From: Laura Gibbons
Sent: 10 June 2019 14:30
To: Planning.Responses
Cc: Anita Gardner
Subject: RE: Planning Consultation on: LU/126/19/PL

Engineers Comments Regarding Surface Water Drainage

APPLICATION NO: LU/126/19/PL

Site Address: 25 River Road Littlehampton BN17 5BZ

Proposed Drawings:
Terminus Place
Roof Plan

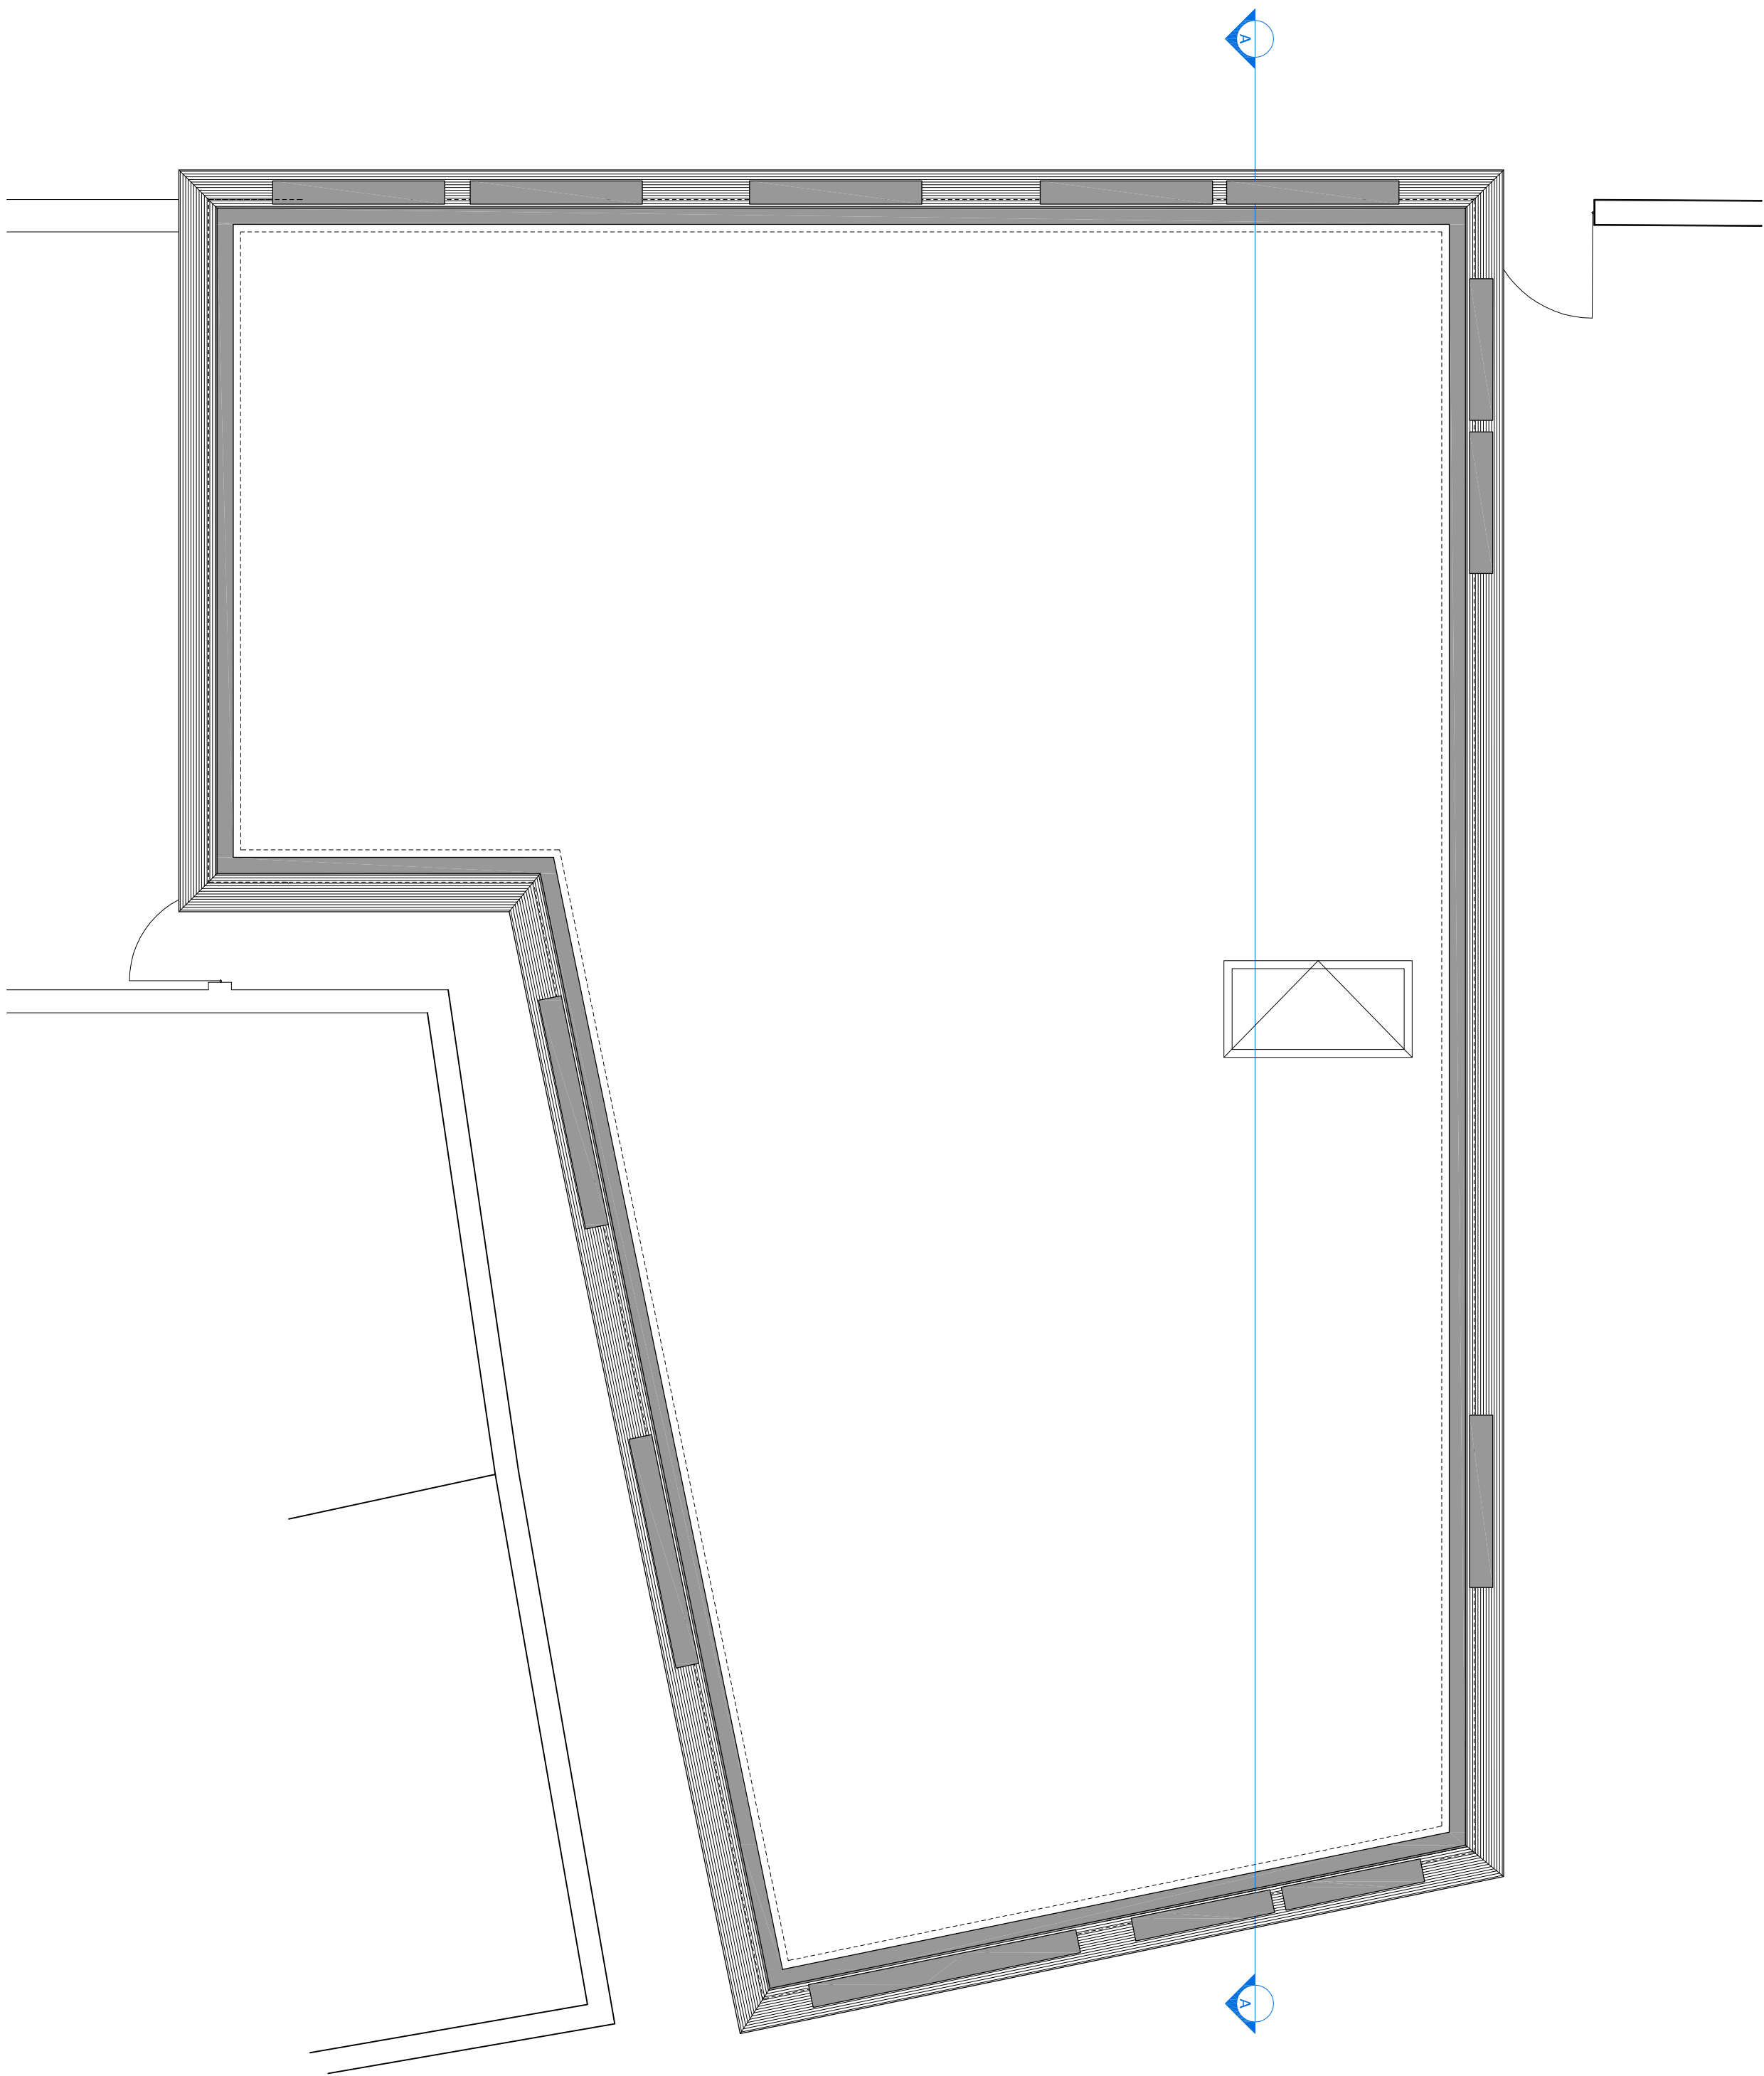
It should be noted that the site is within flood zone 3, the Environment Agency consulted. Surface water shouldn't be stored within flood zone 3, green or blue roofs could be examined.
